**Application Reference: 2026/0320**

**Site Address:** 1 Redthorpe Crest, Redbrook, Barnsley, S75 1JE

This application seeks full planning permission for the erection of a single storey side extension to the eastern elevation.

Drawing Title **PROPOSED ELEVATIONS**

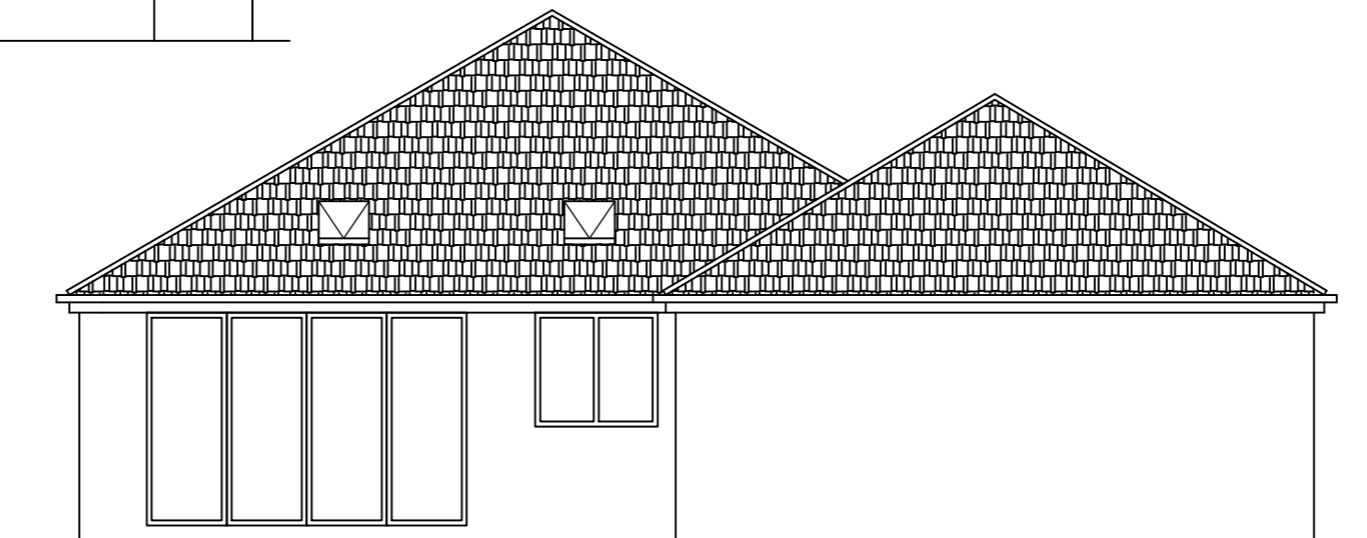
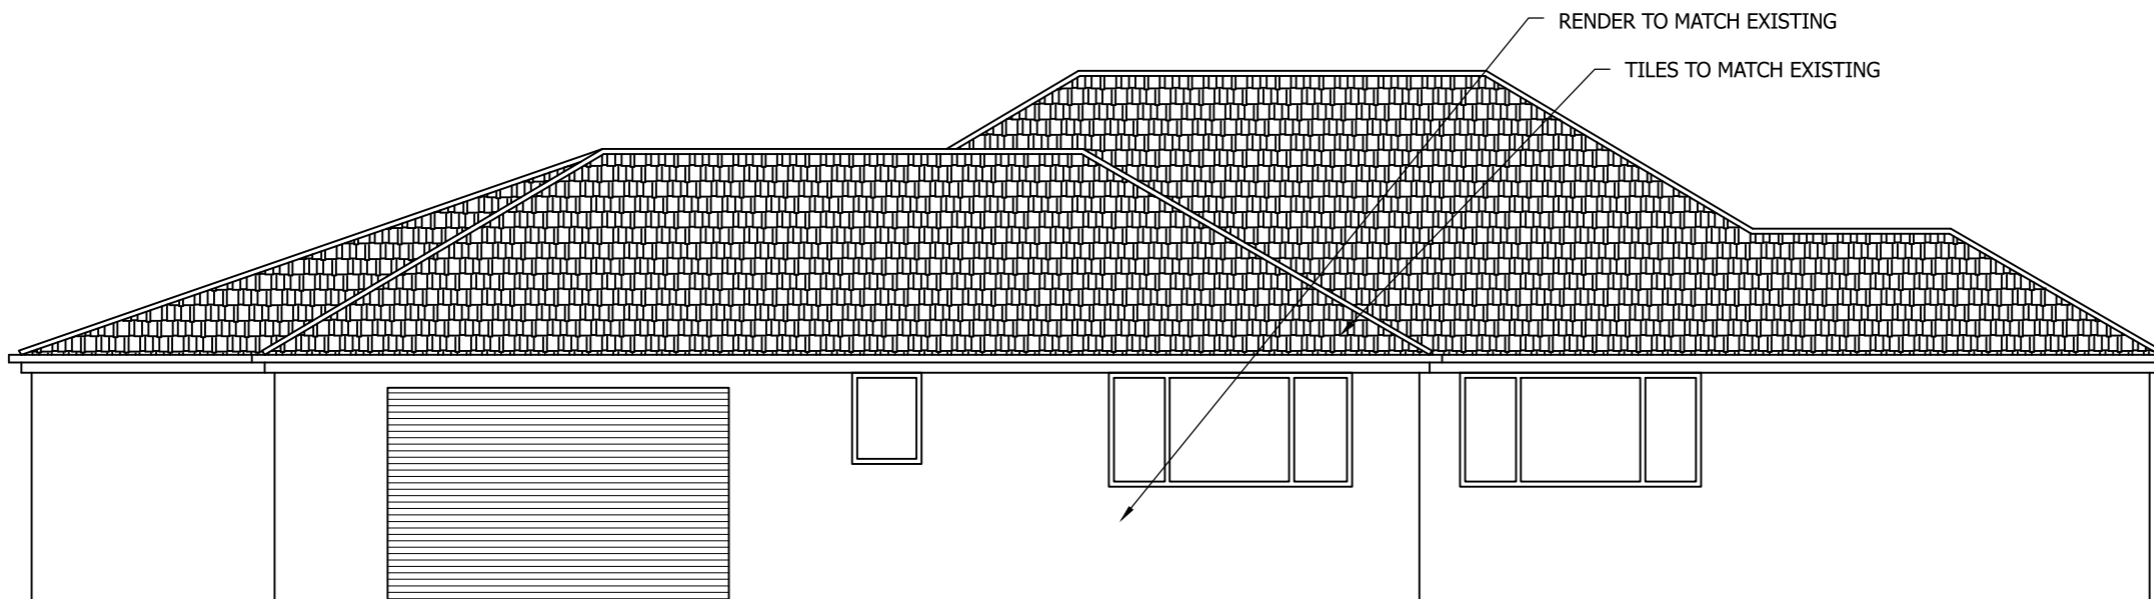
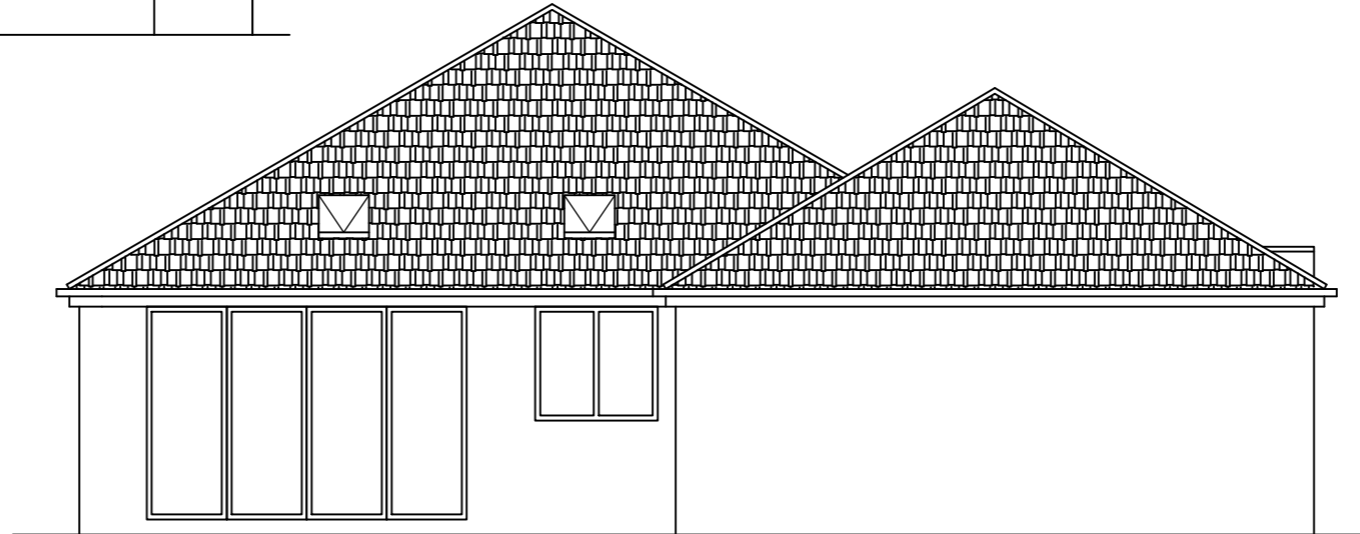
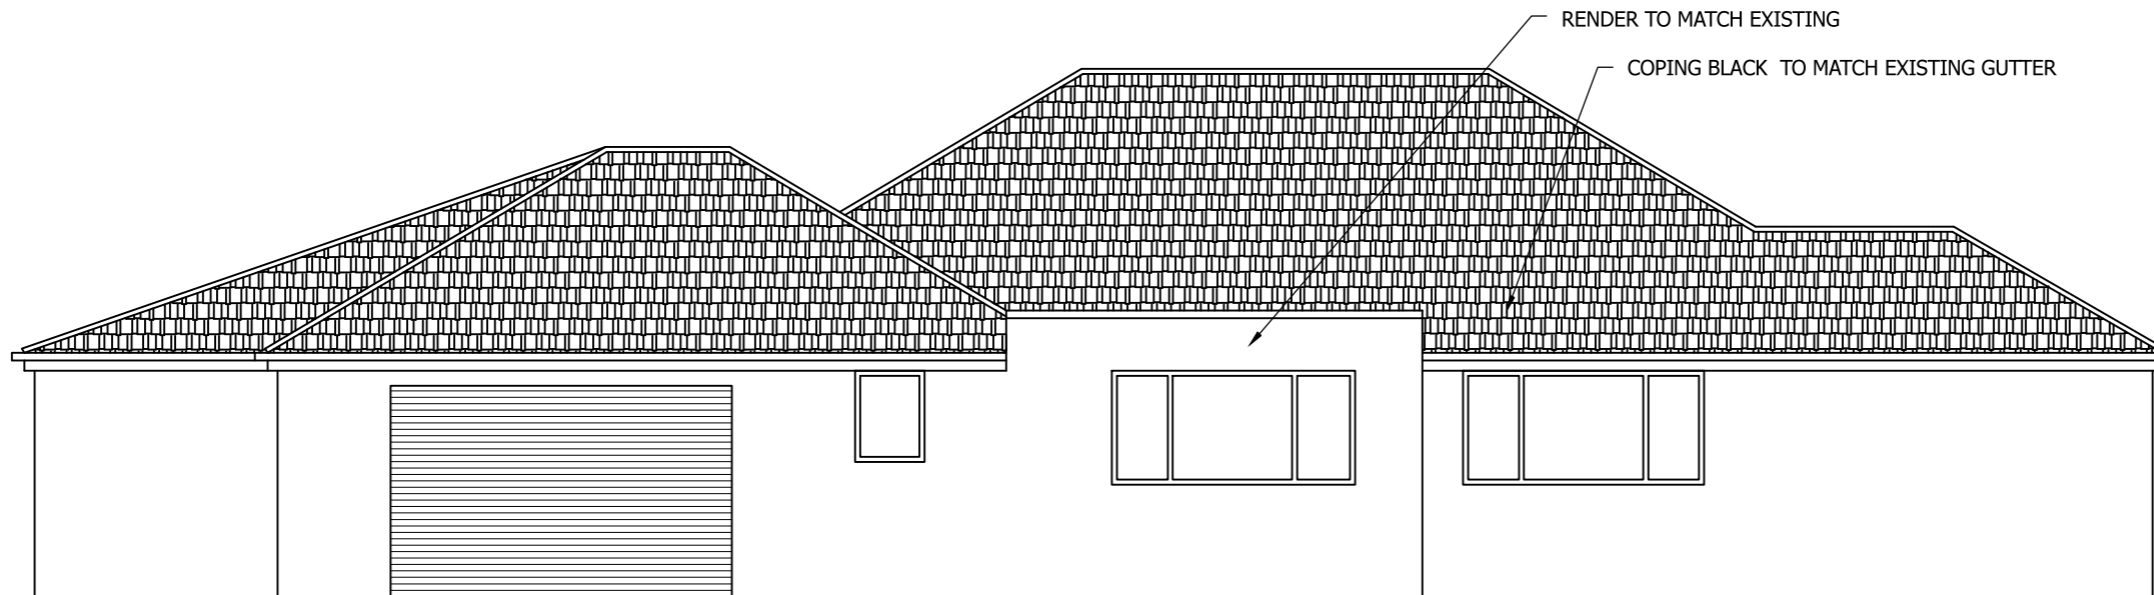
Supplementary Planning Document House extensions and other domestic alterations states that the design of single storey side extensions should reflect the design of the existing dwelling in terms of roof style, pitch, materials and detailing and should not have an excessive sideways projection i.e. more than 2/3 the width of the original dwelling. In this instance the proposed extensions project 2.8m from each side elevation and therefore complies with the guidance set out in the SPD.

The SPD further states that, on corner plots the sideways projection should not exceed more than half the width of the gap between the side elevation of the original dwelling and the side boundary. The dwelling is set back from the Wilbrook Rise boundary by approximately 7.5m, and the proposed extensions would retain at least half of this gap. The proposal is therefore compliant with this requirement.

The SPD also advises that a two storey side extensions should have a set back from the front elevation by at least 500mm, to allow for a vertical break in the roof plane, a lowering of the ridge line and to lessen the unsightly bonding of old and new materials. While the host dwelling is single-storey, a single storey side extension to a single storey dwelling is

tantamount to a two-storey side extension to a two-storey property and therefore the principle applies in this instance; the extension is set back from the front elevation by approximately 9.5m and as such the development complies with this element of the SPD.

The design of the proposed side extension relates well to that of the original dwelling in terms of roof style, pitch and detailing and the materials proposed, in addition the fenestration of the proposed matches that of the original dwelling. This carries considerable weight in favour of the application, and it is therefore considered that the proposed extension is acceptable in terms of visual amenity and in compliance with Local Plan Policy D1.

In dealing with the application, the Local Planning Authority has worked with the applicant to find solutions to the following issues that arose whilst dealing with the planning application: The extension was initially designed with a flat roof, this was considered an inferior form of construction which was at odds with the dwelling and located in a prominent position.

Drawing Title **PROPOSED PLANS**

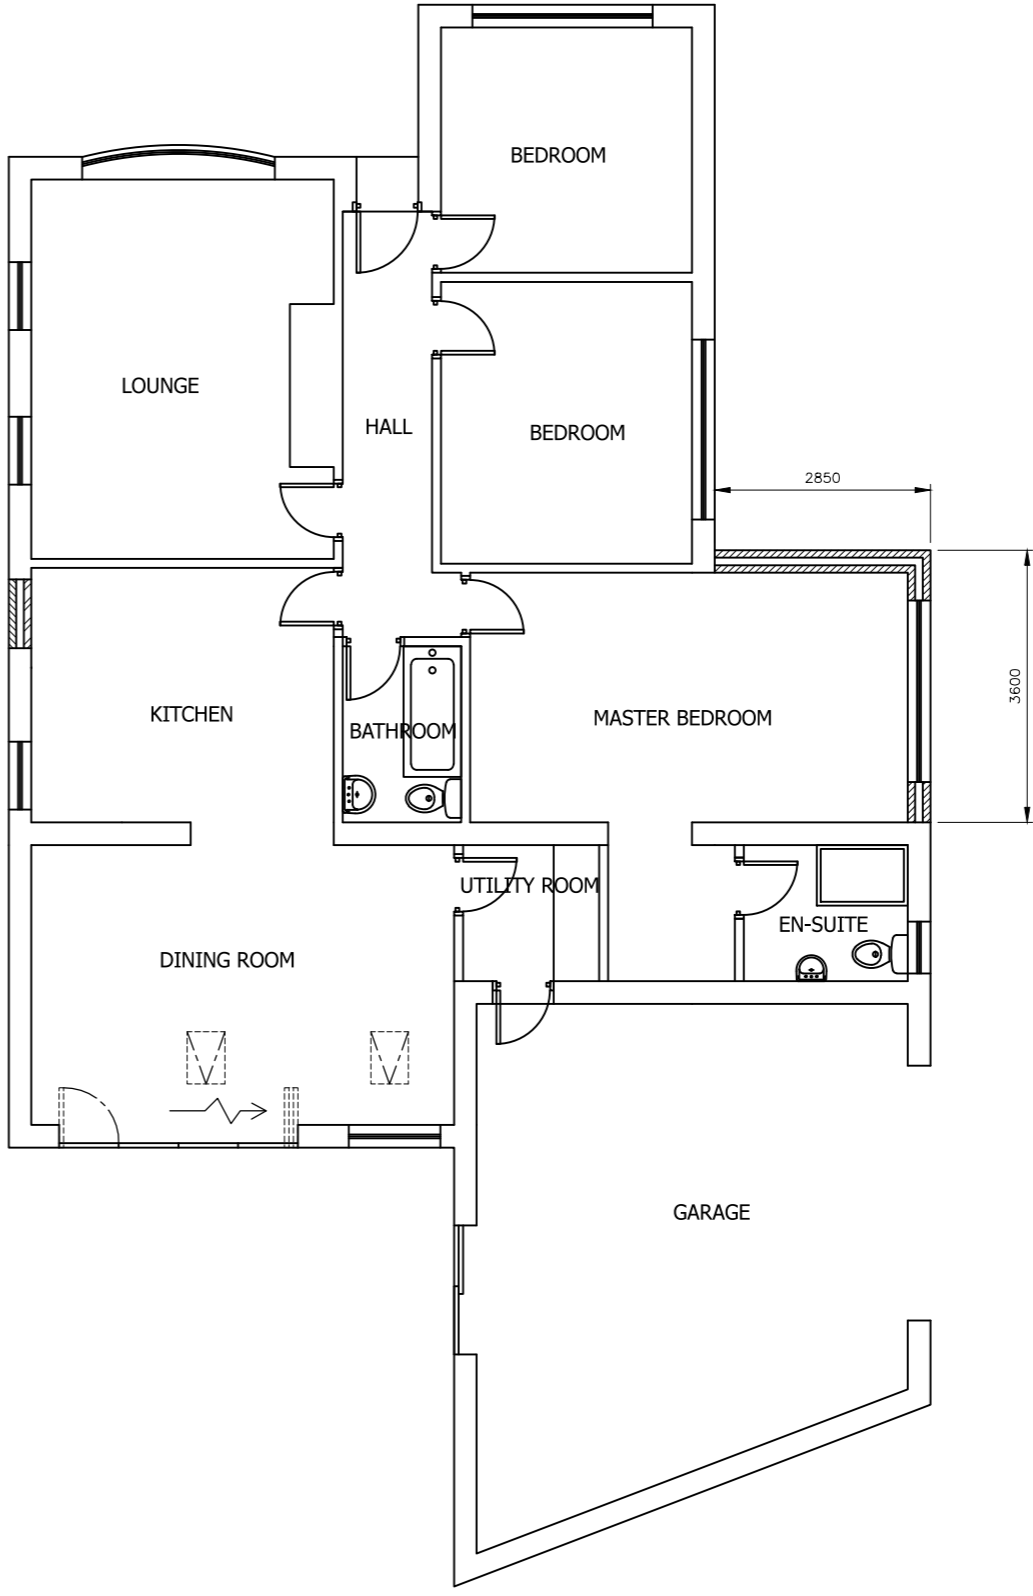
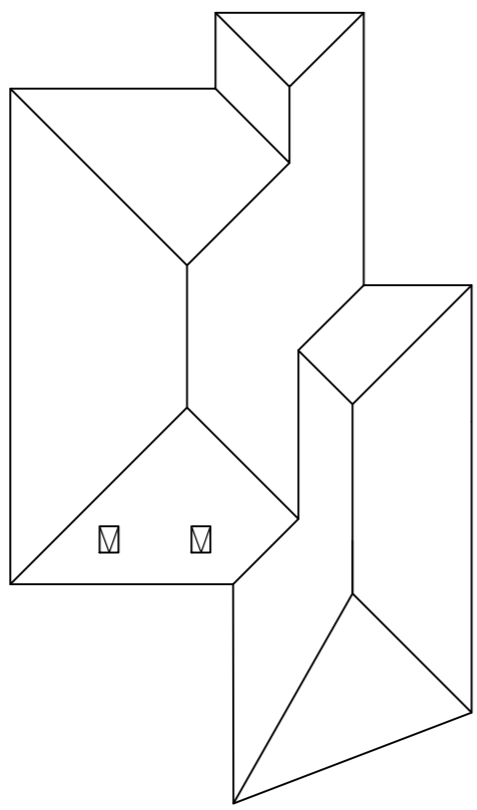
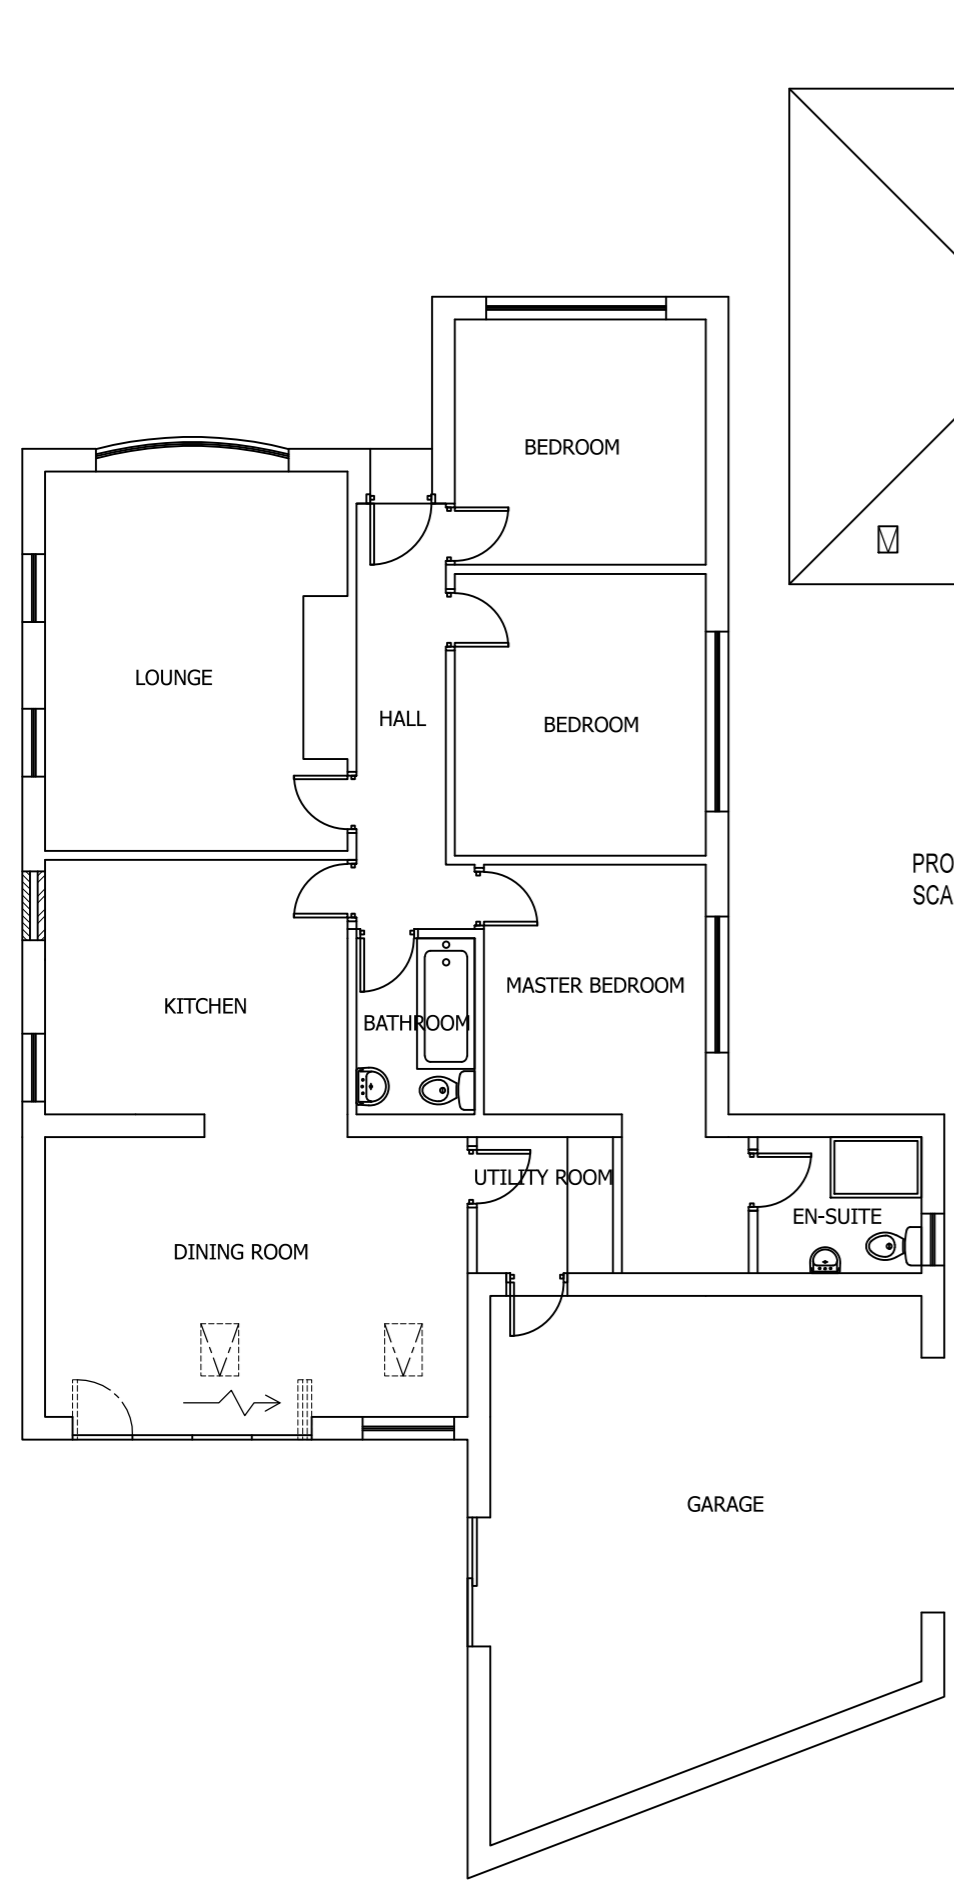
The proposed single storey extension is to be located on the eastern side elevation of the dwelling within the building line of the original dwelling and the approved extension under application 2021/0430. As such there would be no detrimental increase in overshadowing or reduction in outlook from the neighbouring dwellings. This carries considerable weight in favour of the application.

The SPD advises that facing habitable room windows should maintain a separation distance of 21m. The proposed side window would be located approximately 20m from the habitable room windows on the opposing property which fronts onto Wilbrook Rise. It is acknowledged that the development falls slightly short of the required separation distance, however, it is not considered that the shortfall would lead to an increase in overlooking given that the dwellings are separated by the highway and the window is located at ground floor level, with the existing boundary treatment acting as suitable screening. This carries limited weight against the application.
